Application no: 23/03073/HYBRID

Location: Phase 2 SW Bicester Kingsmere Parcel R East Of, Ludlow Road, Bicester

Transport Schedule

Recommendation: Objection

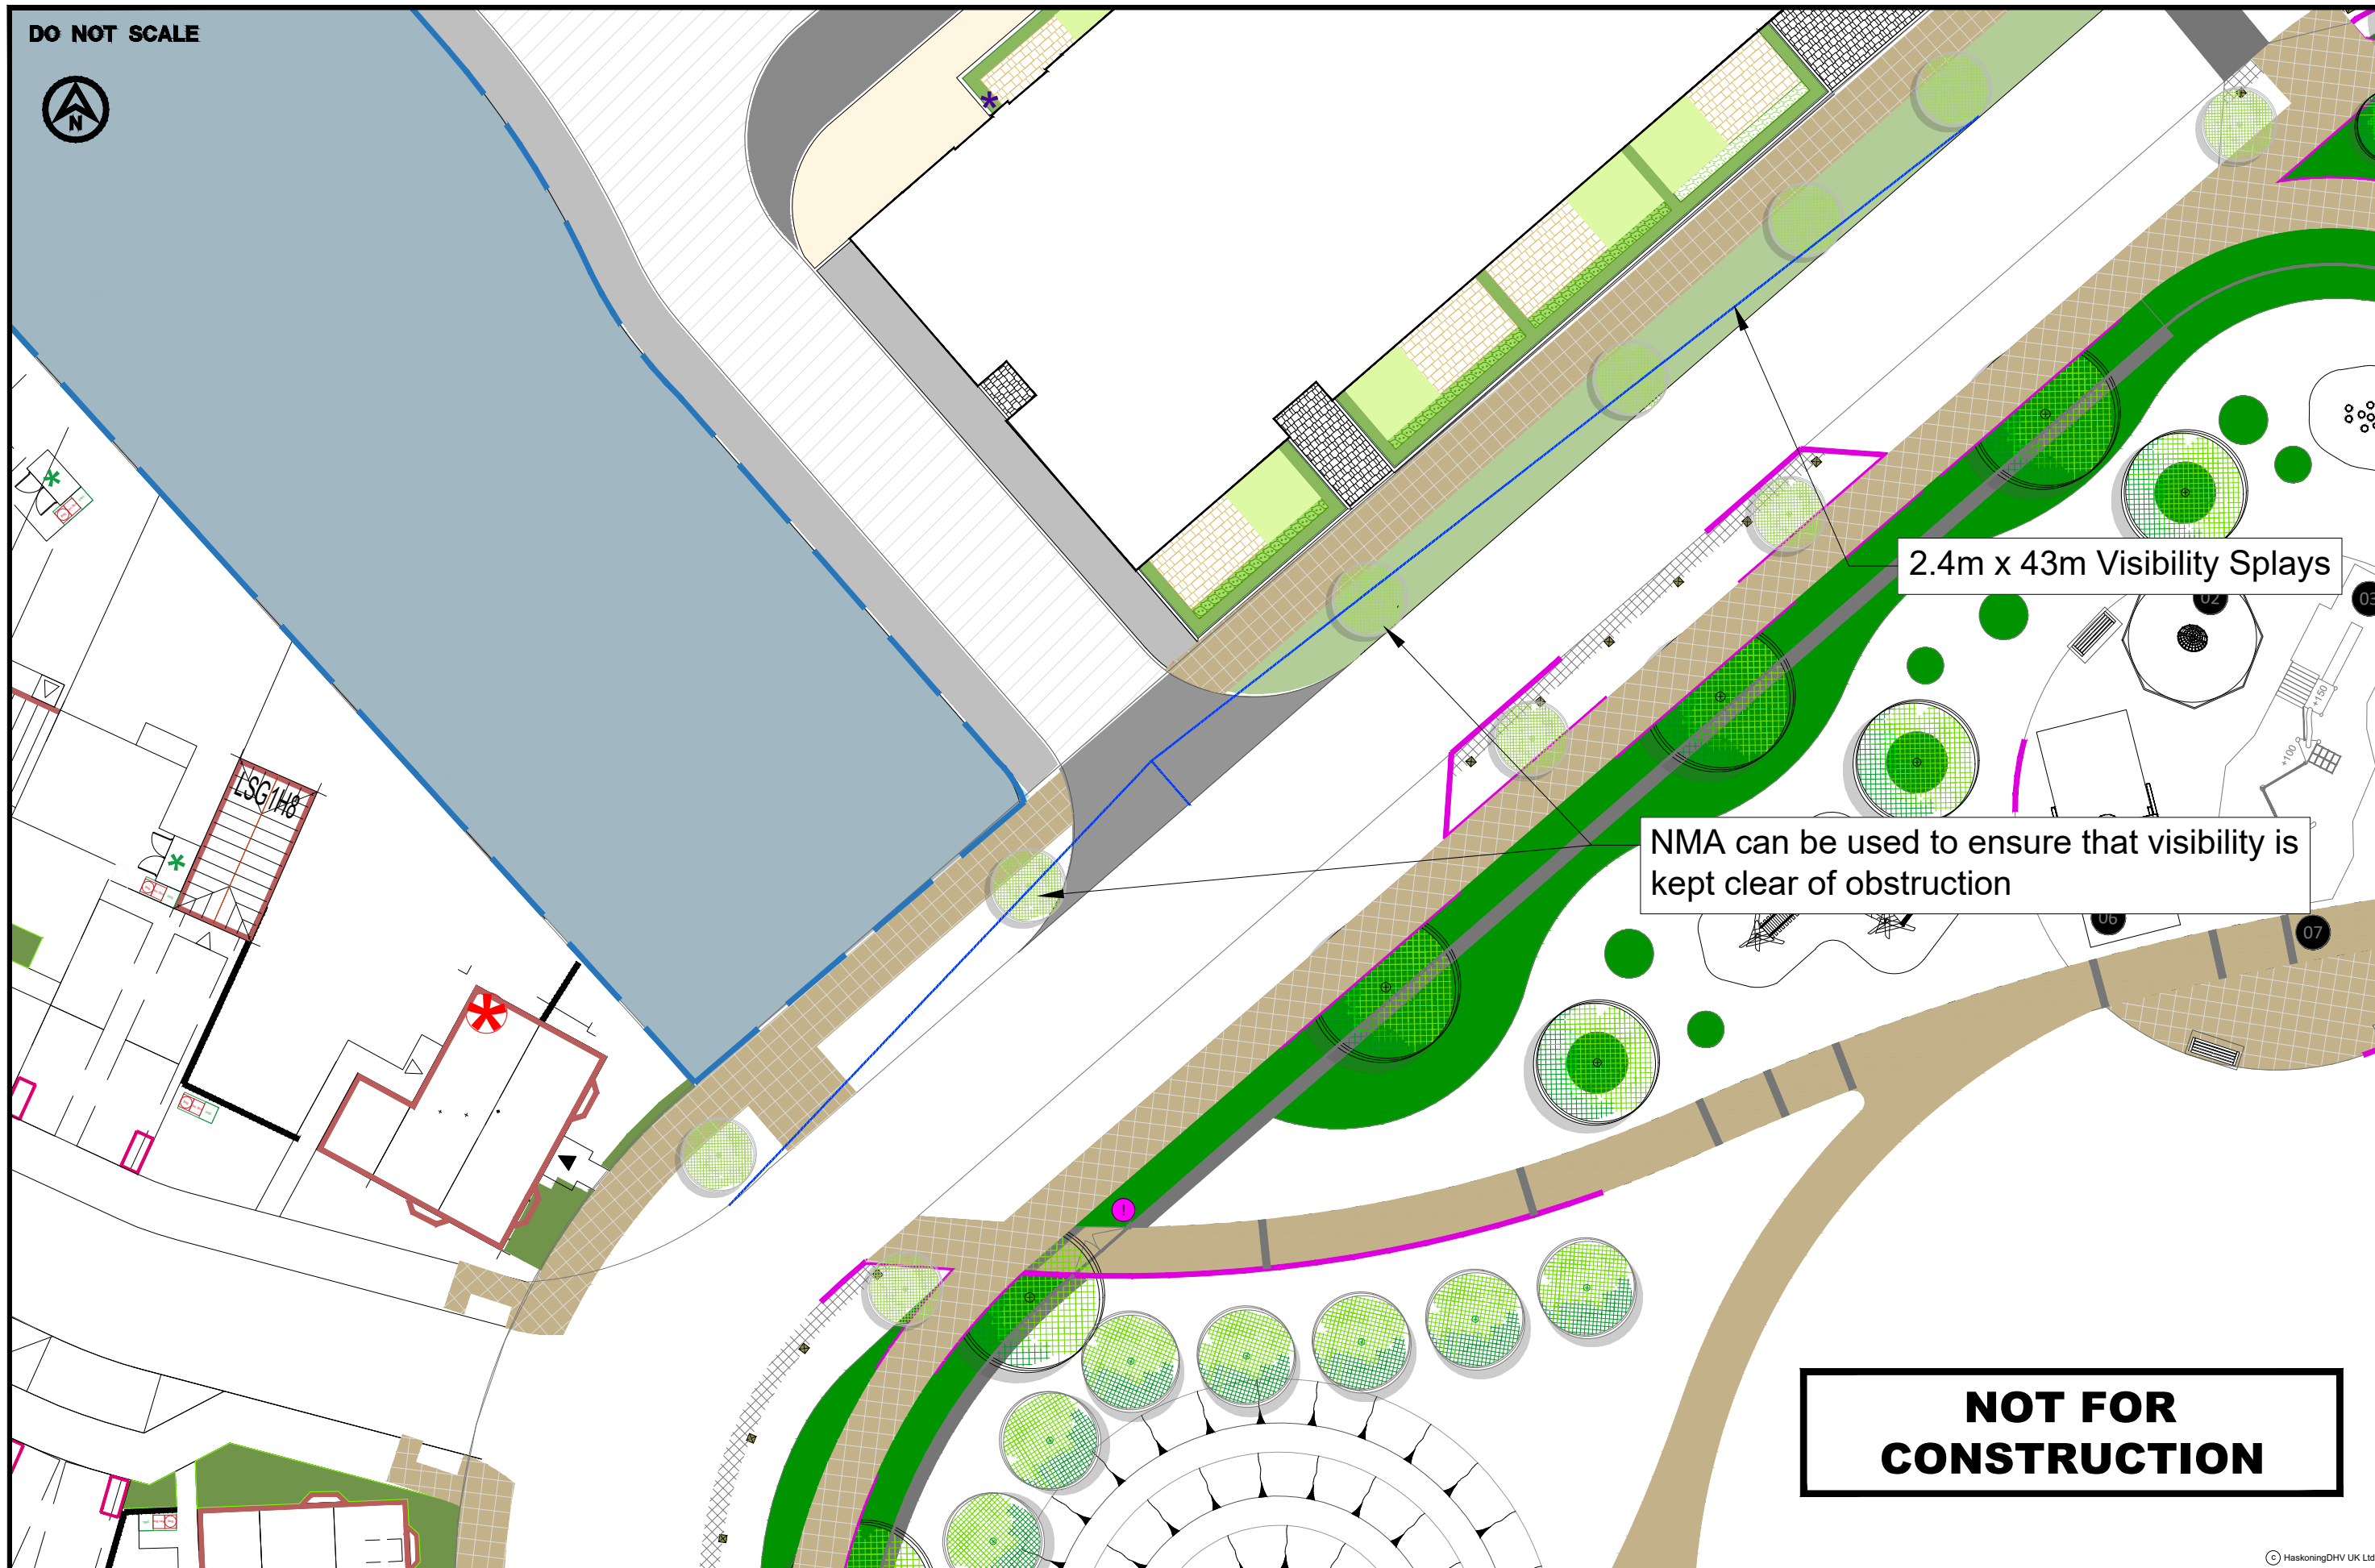
Although the required safe visibility splays appear to be contained within the public highway there appears to be possible obstructions within it (e.g. shrubs / wall). The visibility splay should be free of obstructions 2m high down to a point 600mm above the carriageway. Trees should not be positioned within visibility splays. It is noted that the applicant is willing to address this issue by ensuring that there is no obstructions within the visibility splays.

Drawing Title: Proposed Site Layout Plan

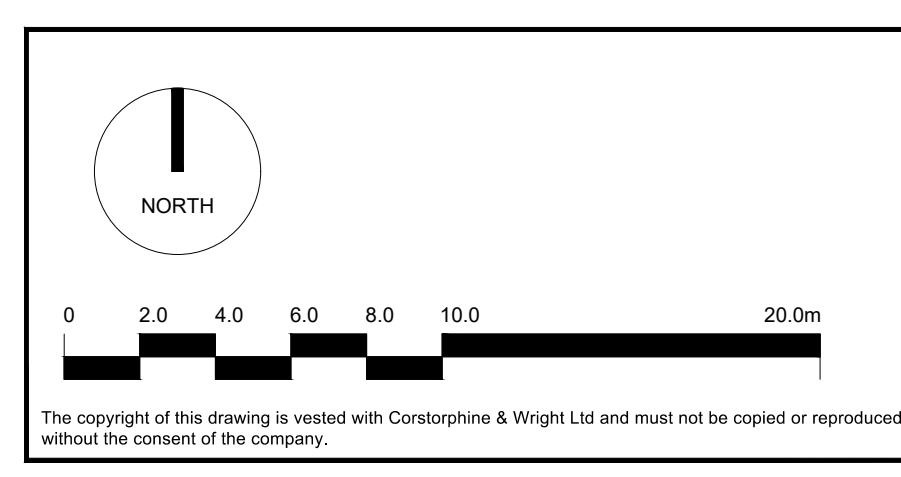
The bicycle parking facilities should be located in a fully accessible location and closer to the main access points of the development with a clear path available.

The dimensioned site layout plan indicates some aisle widths of 4.63m near turning paths which is narrow for two-way vehicle movements. Safe two-way vehicle movement has not been demonstrated.
